**Re:** Proposed flood relief scheme  
in Mountmellick, County Laois

**Re:****Mountmellick Flood Relief Scheme – Observation under:**

The below-signed residents of Derrycloney, Mountmellick (Residents) are making this observation in relation to the proposed Mountmellick Flood Relief Scheme (FRS), particularly its impacts on properties in the Derrycloney area located on the high bank of the river.

Figure 2-3: Undefended Scheme

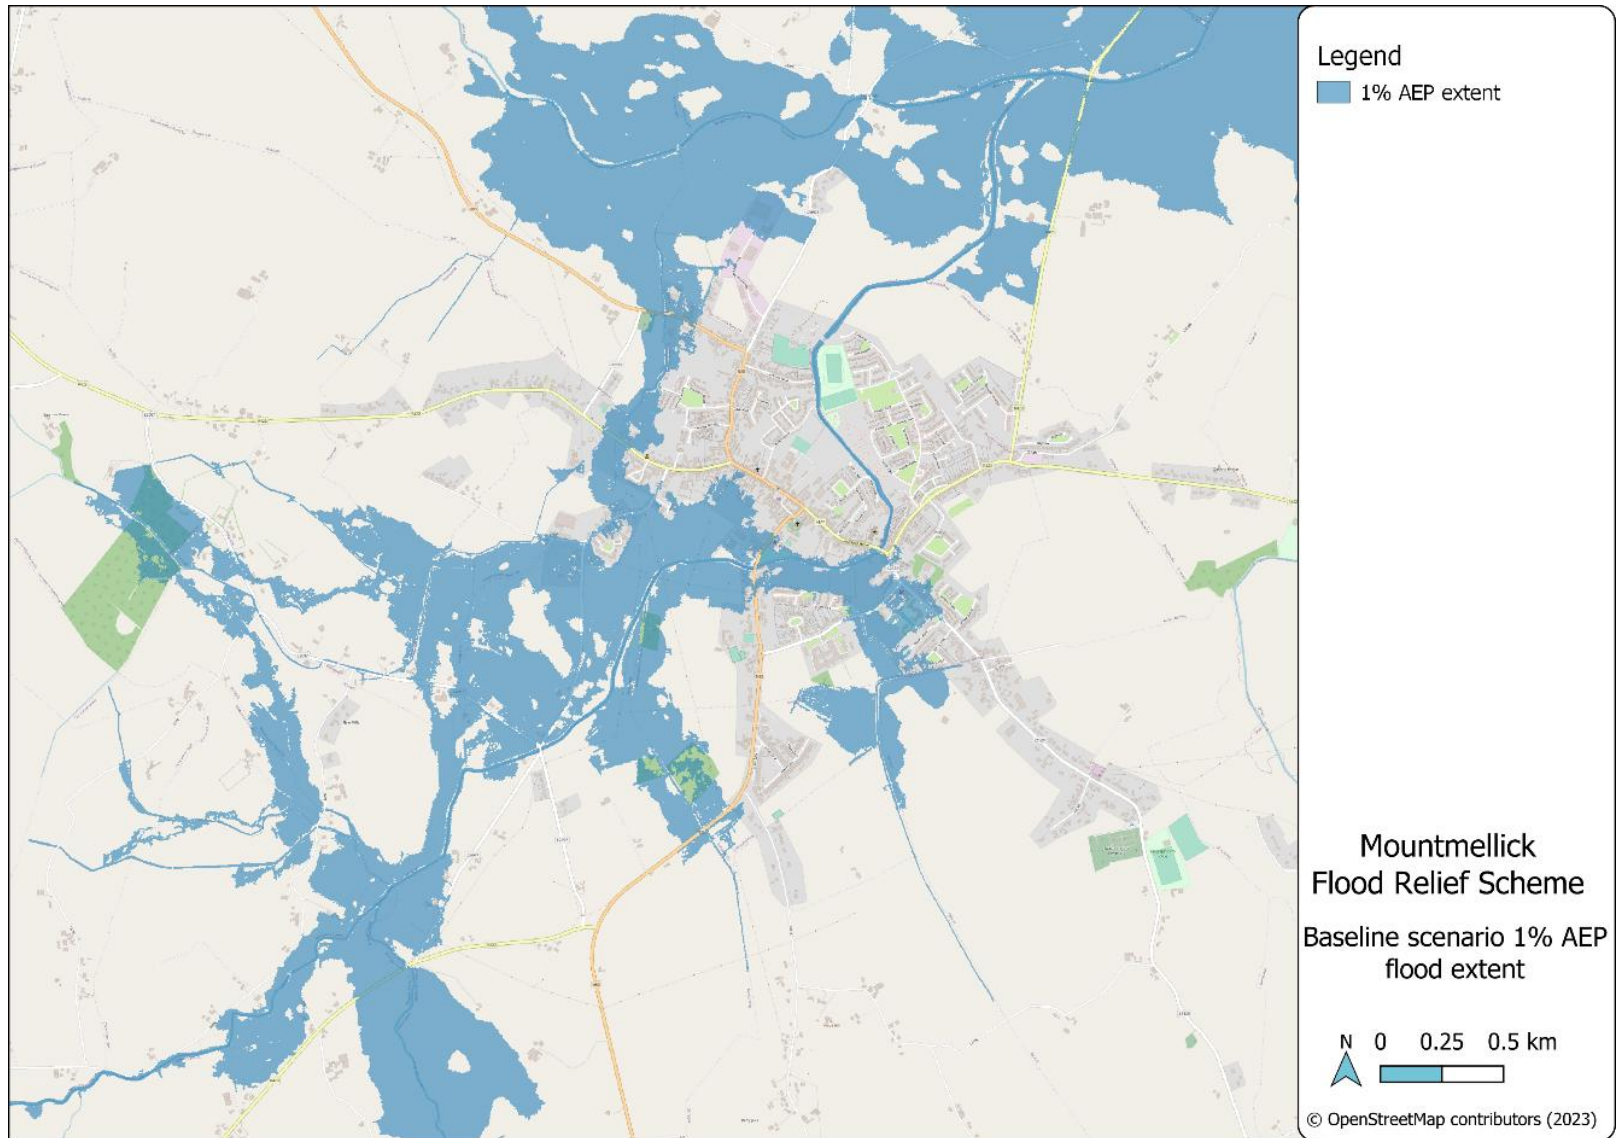
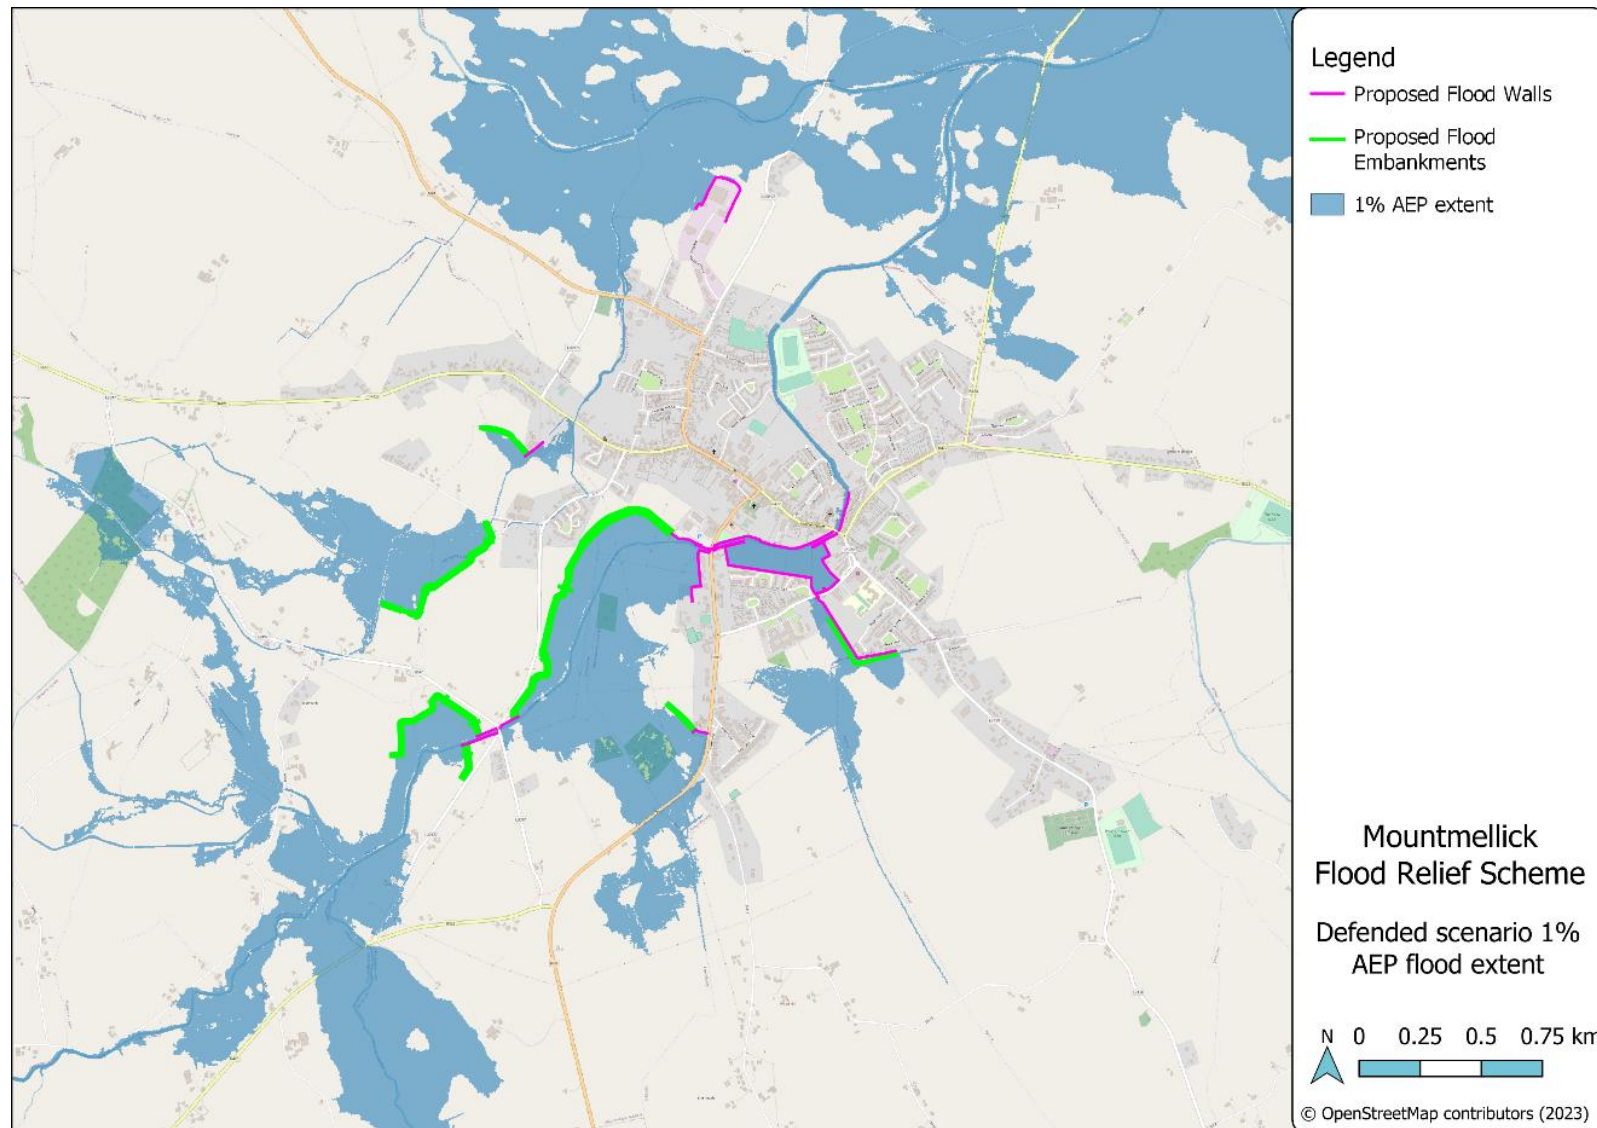
However, the current proposal introduces an unacceptable and avoidable increase in flood and pollution risk for existing houses on the high bank of the river at Derrycloney. At present, these houses enjoy a high level of protection because:

By constructing walls and embankments along the low bank, the proposed FRS will:

- Remove or significantly reduce the existing floodplain storage on the low side.
- Increase water levels and flood depths adjacent to the high bank properties.
- Do so without incorporating reasonable, technically feasible mitigation measures that have been brought to the designers' attention.

In effect, the proposed FRS protects properties on the low bank by transferring residual and climate-change-driven risk to the high bank properties, which is contrary to good flood-risk management practice and to proper planning and sustainable development.

- o 1% AEP HEFS to 2100, and
    - o 0.1% AEP baseline, including appropriate climate allowances.
  3. If the modelling confirms that the proposed FRS increases flood risk to the high bank properties or to their wells and septic tanks, require the design to be modified to incorporate reasonable mitigation measures, such as:

- o Extension and/or reconfiguration of embankments/walls (east and/or west) to ensure that the high bank properties are not left in a lower standard of protection than they currently enjoy.

- 1% AEP extent
- 1% AEP MRFS extent
- 1% AEP HEFS extent

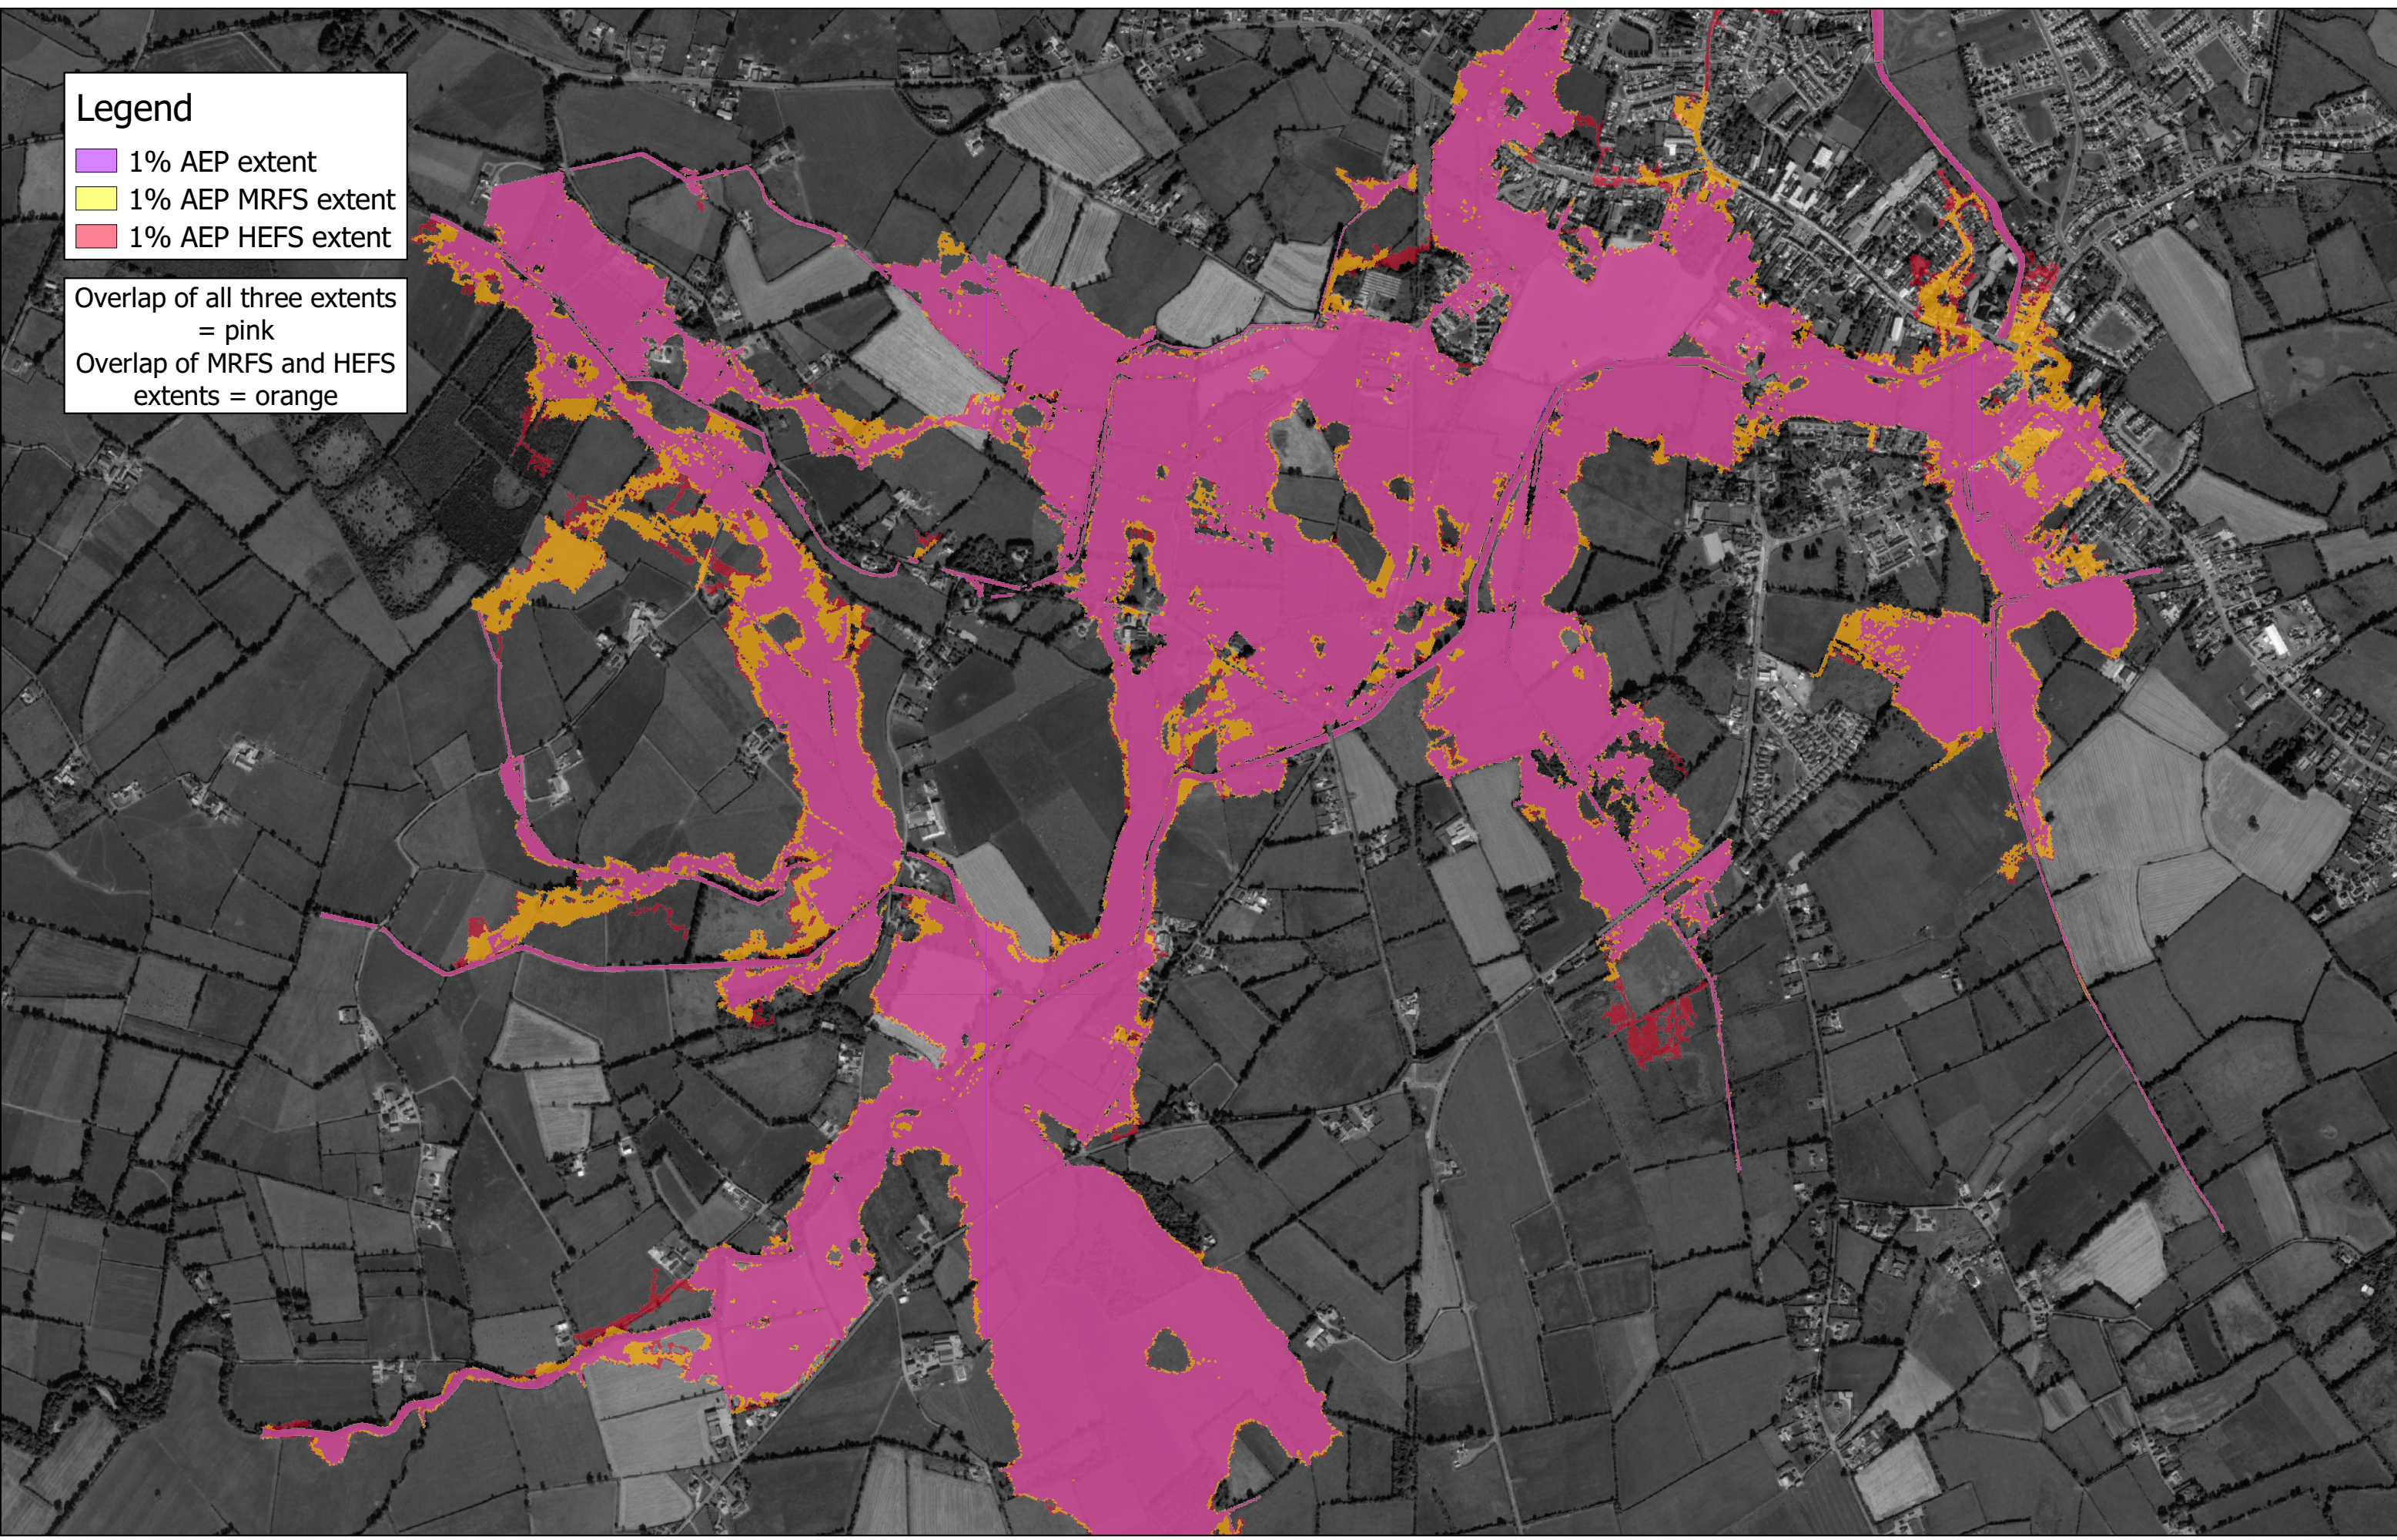
- Scenario 1 (1% AEP): the model shows no flooding at the houses themselves.
- Scenario 2 (1% AEP MRFS): the model already shows at least one well and one septic tank at these properties being overtopped.
  - o This creates a serious risk of contamination of private drinking water supplies.
  - o Neighbouring wells draw from the same groundwater source, so multiple households could be affected.

The modelling indicates that at some point between scenario 1 (1% AEP) and scenario 2 (MRFS), at least one well and one septic tank at the high bank houses will be topped by floodwater. Given the connectivity of groundwater in this area, neighbouring wells draw from the same or connected aquifers and are therefore also at risk.

- The documents made available as part of this planning application still show the original flood map, even though both the residents and the consultants accept that this mapping underestimates flooding in Derrycloney. This is reflected in updated flood maps shared with Derrycloney Residents on 7 August 2025, belatedly responding to a request from Derrycloney Residents for updated information issued on 20 April 2024.
- This is likely to mislead the public and decision-makers regarding:
  - The true extent of flood risk in the area,
  - The true extent to which the FRS may increase risk to the high bank houses.

1. Require updated and complete hydraulic modelling and mapping to be submitted as part of the application, reflecting:
  - o The latest agreed model for Derrycloney,

- o Flood extents and depths for all six scenarios, with and without the FRS, clearly showing differences for both low bank and high bank properties.
2. Require the scheme promoters to demonstrate, with this updated modelling, that the FRS will not materially increase flood levels or risk to the high bank houses for at least:
